WOODMOOR

Water & Sanitation District No. 1

April 22, 2021

RE: Cloverleaf Subdivision – Preliminary Plan Set

PRELIMINARY UTILITY PLAN

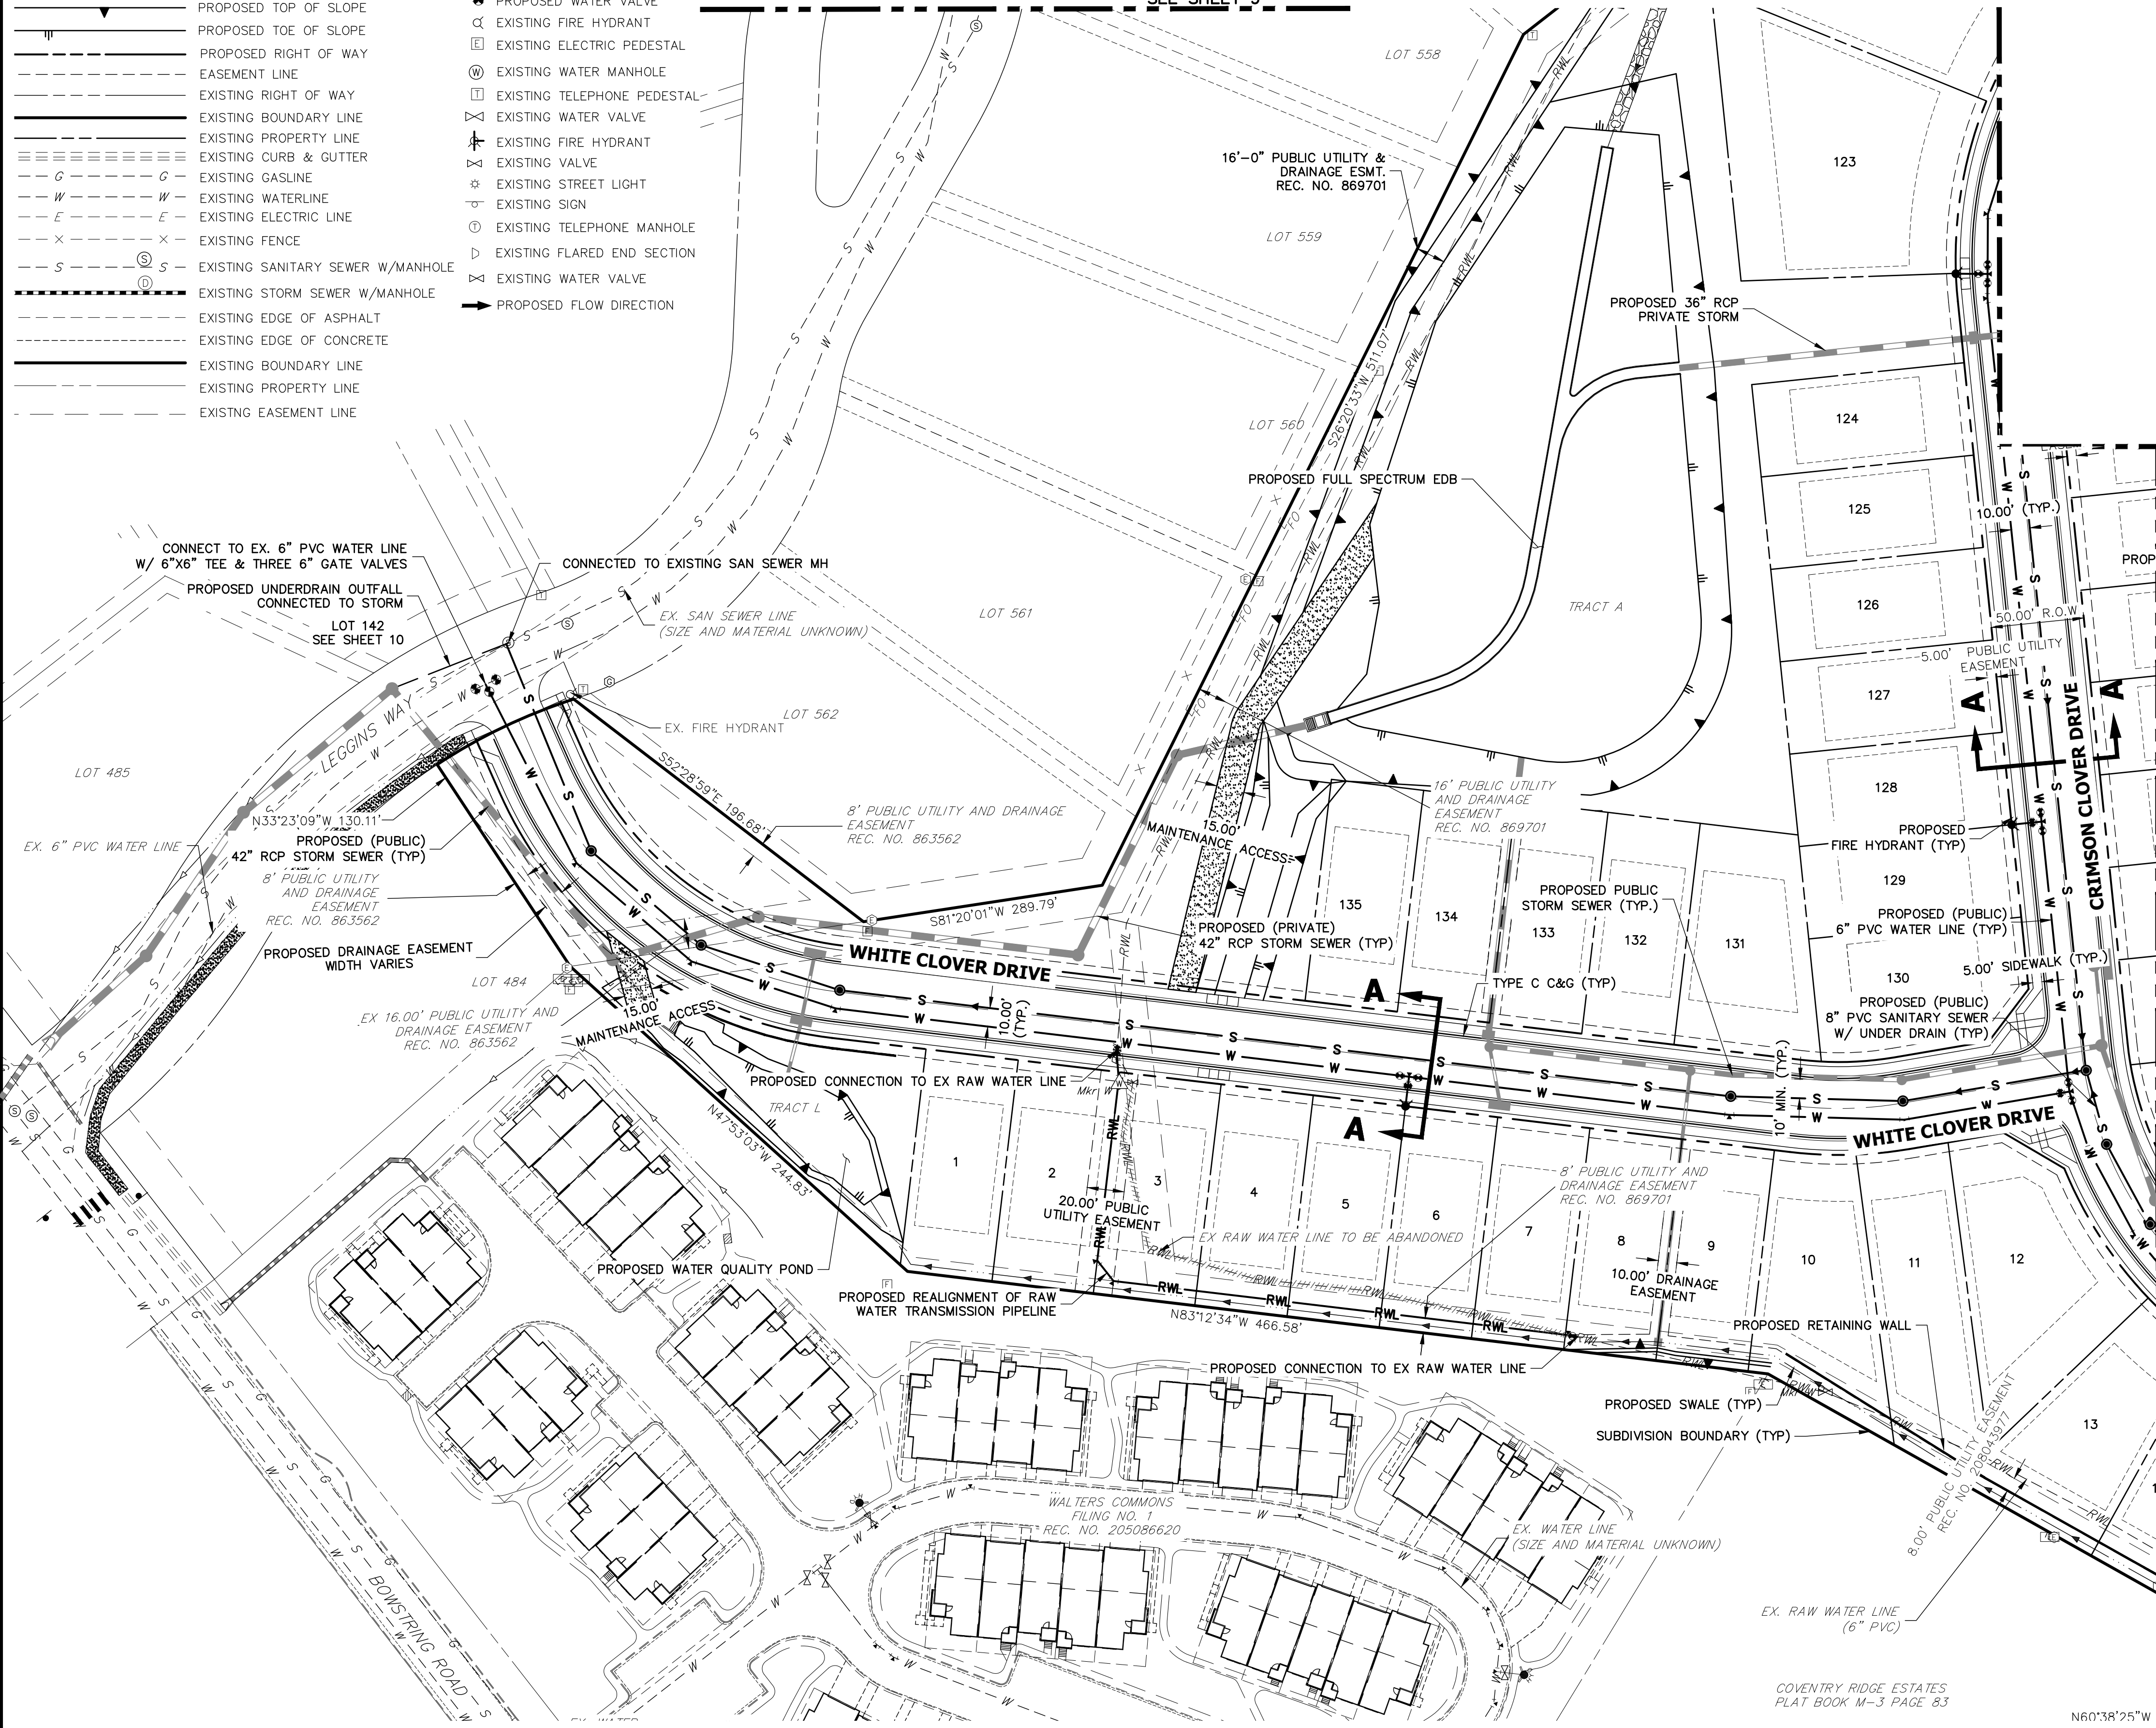
1. On the northern end of Alsike Clover Court, there is a dead-end manhole and a re-routed sanitary sewer pipeline. How will services be connected to these pipelines?
2. Will valves be installed at the raw water tie-ins to existing?

SHEET 7 OF 14
JOB NO. 25158.01

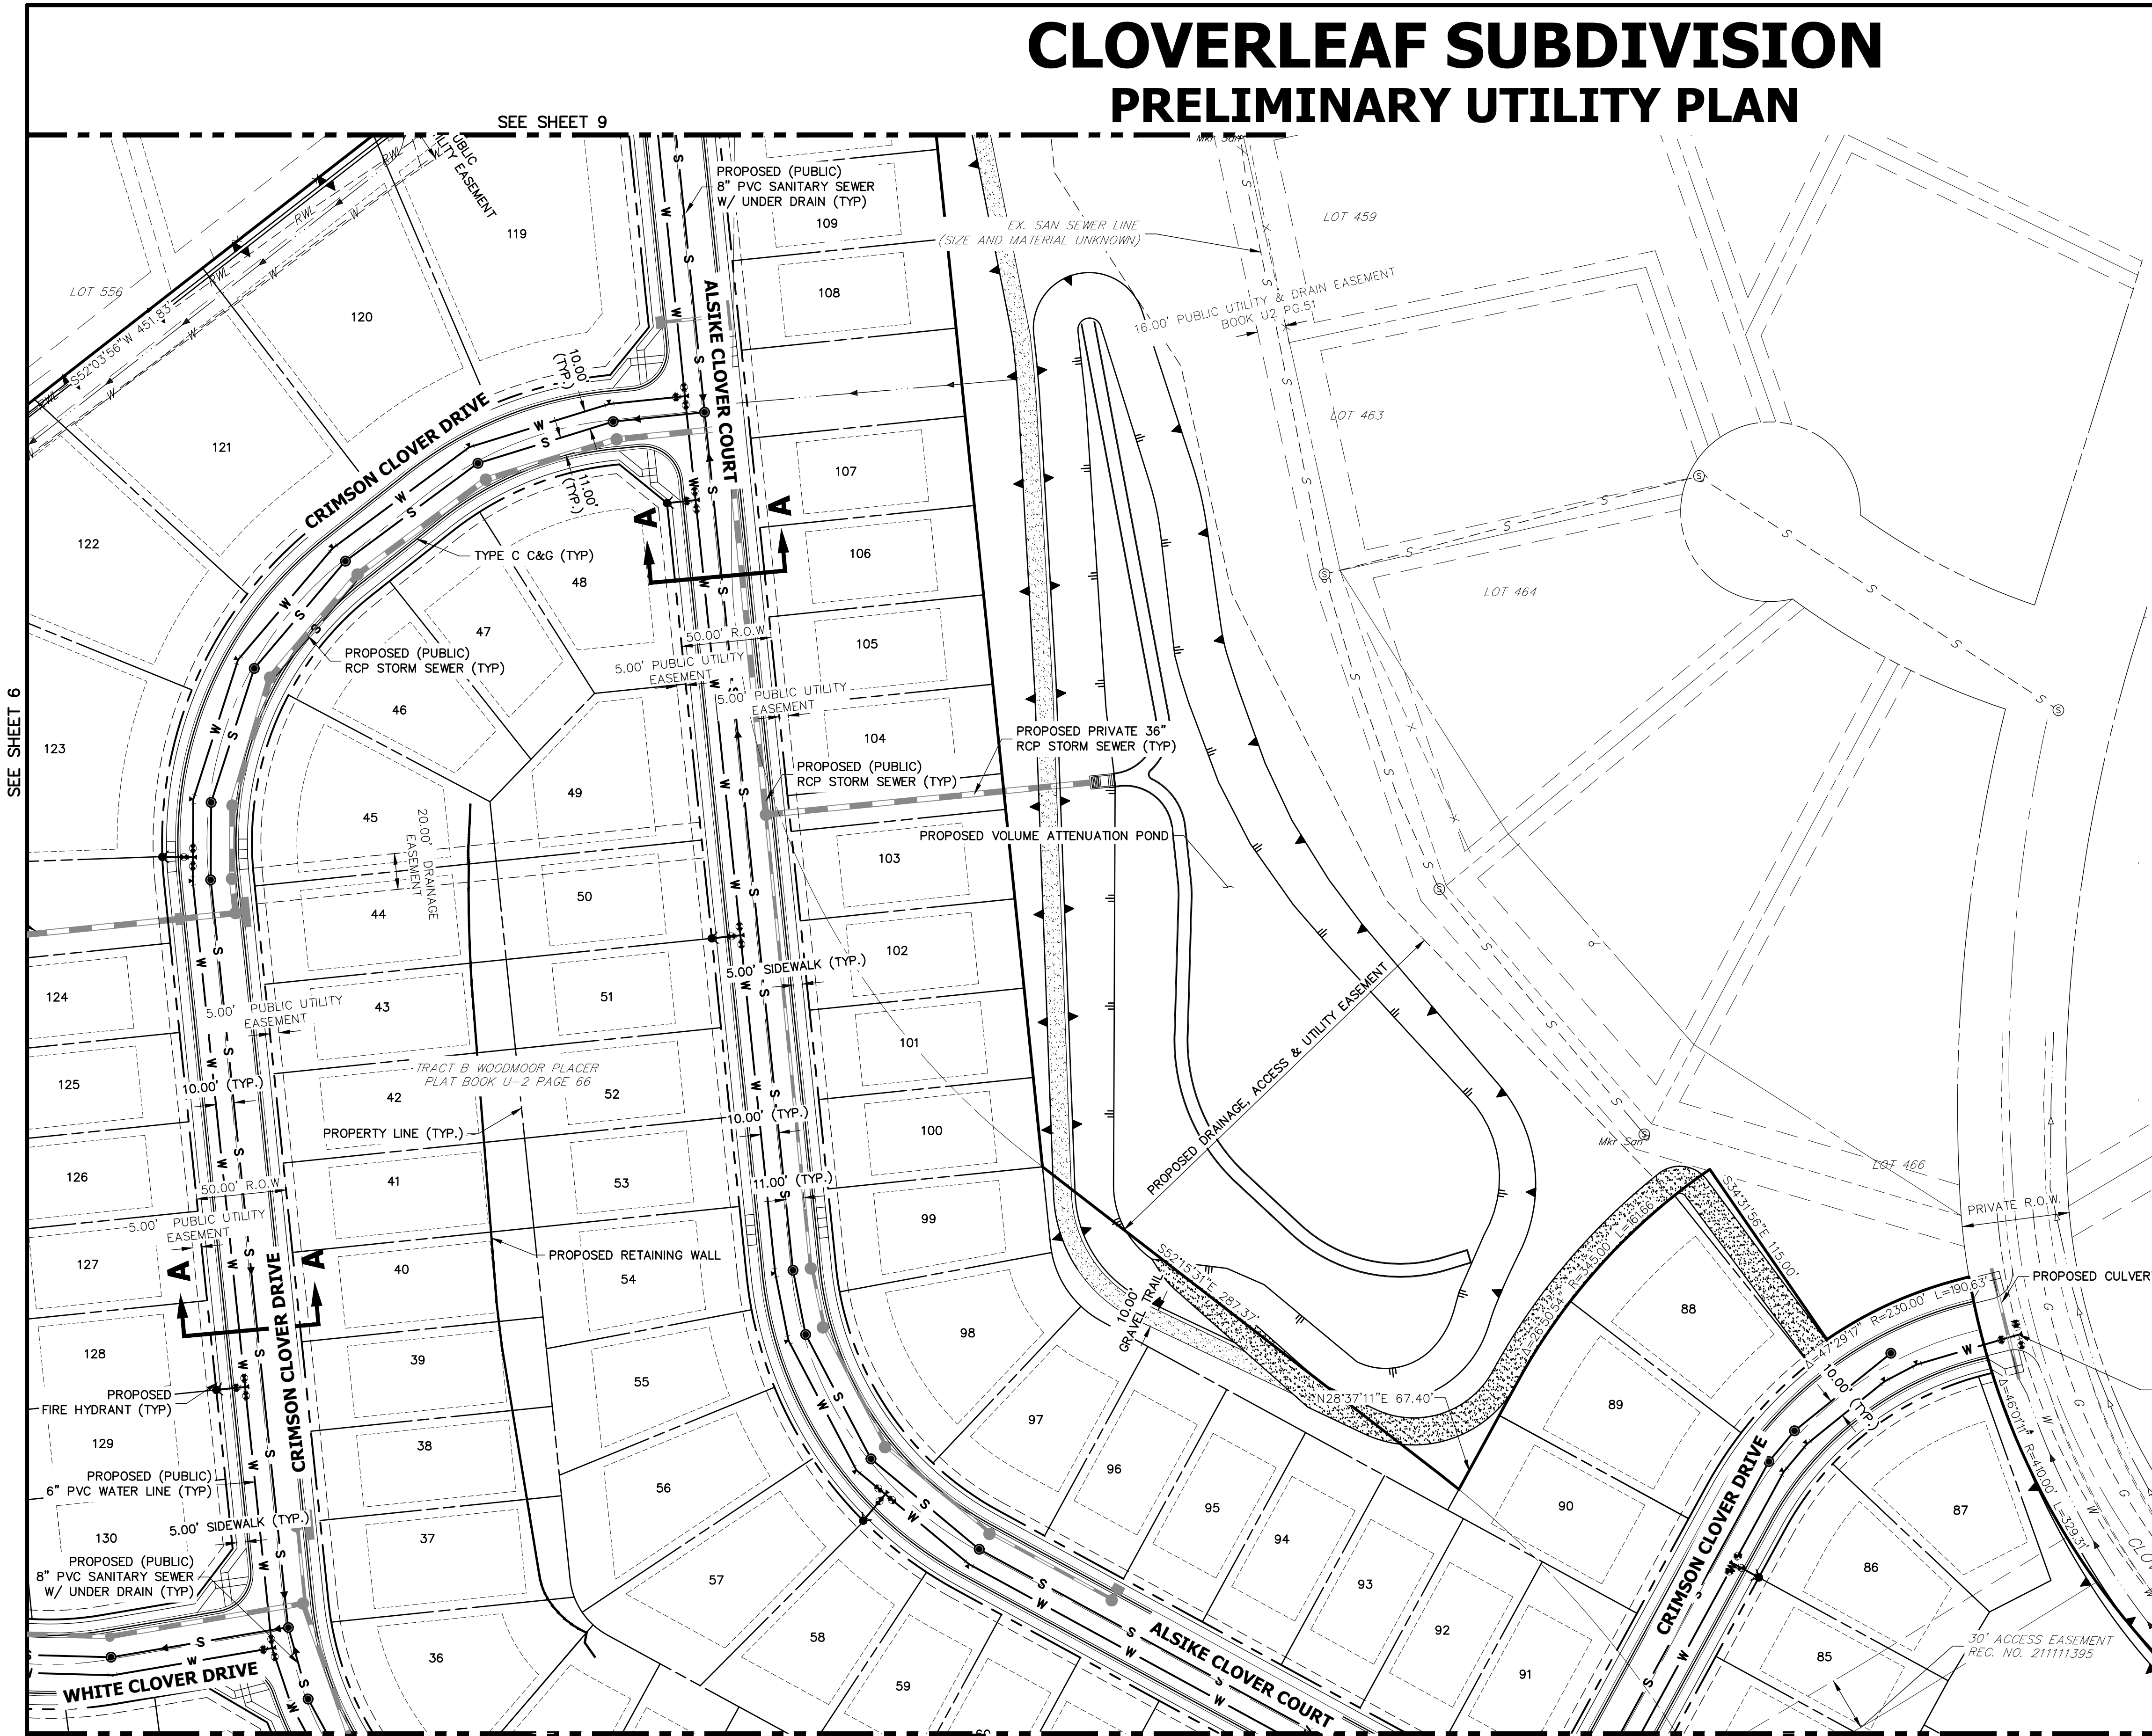
1. In Walters Point, the sanitary sewer pipeline cannot bend or curve. Please add a manhole at each necessary bend between tie-in point and manhole in front of lot 137 or Lot 138.

CLOVERLEAF SUBDIVISION
PRELIMINARY UTILITY PLAN
SHEET 8 OF 14
JOB NO. 25158.01

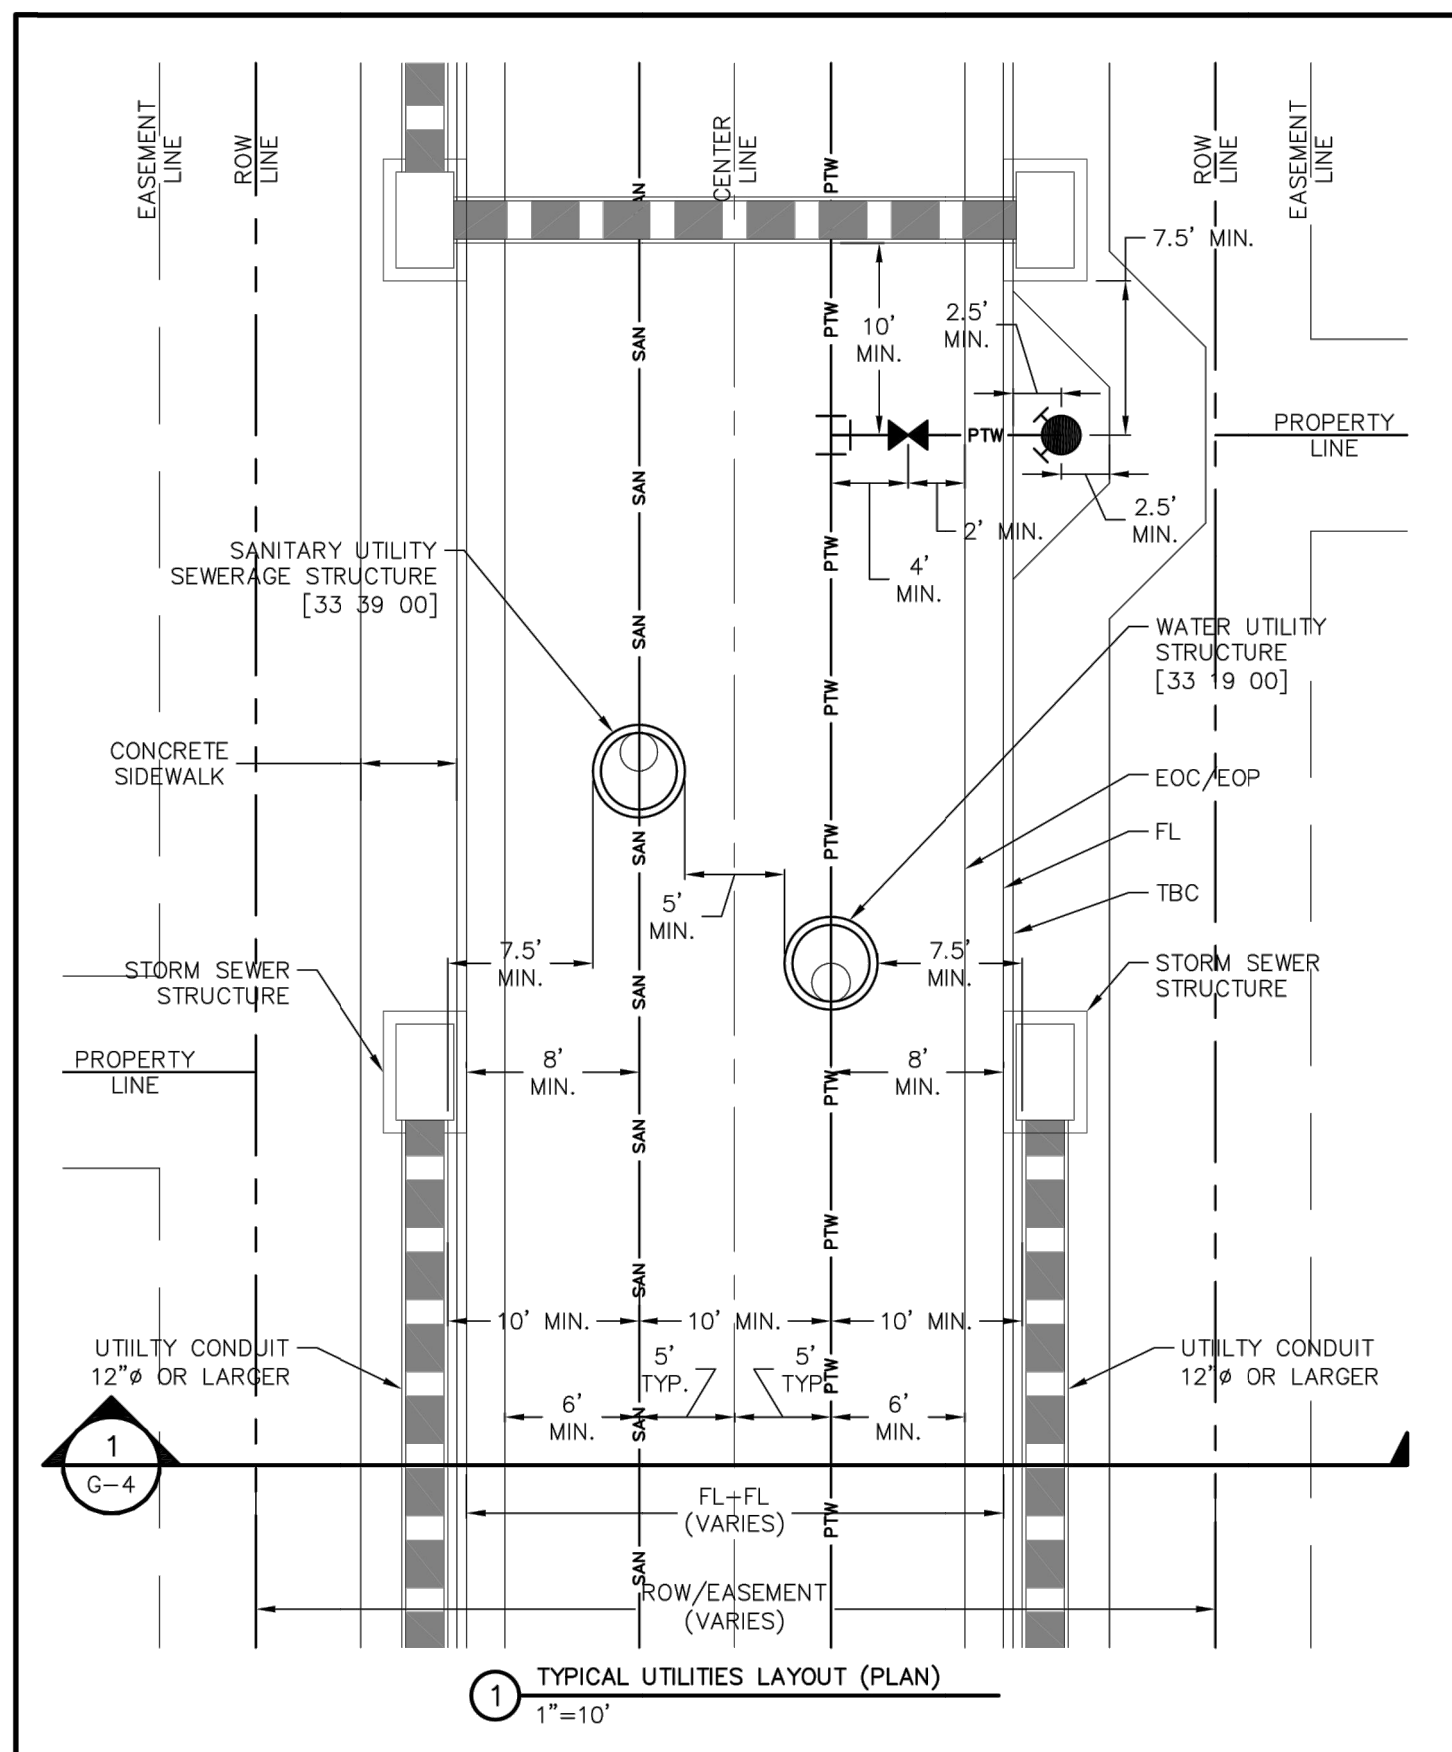
1. Has it been verified via potholing that there are no existing utilities within the 16.00' public utility easement, Book 5437 Pg 646, proposed to be vacated?
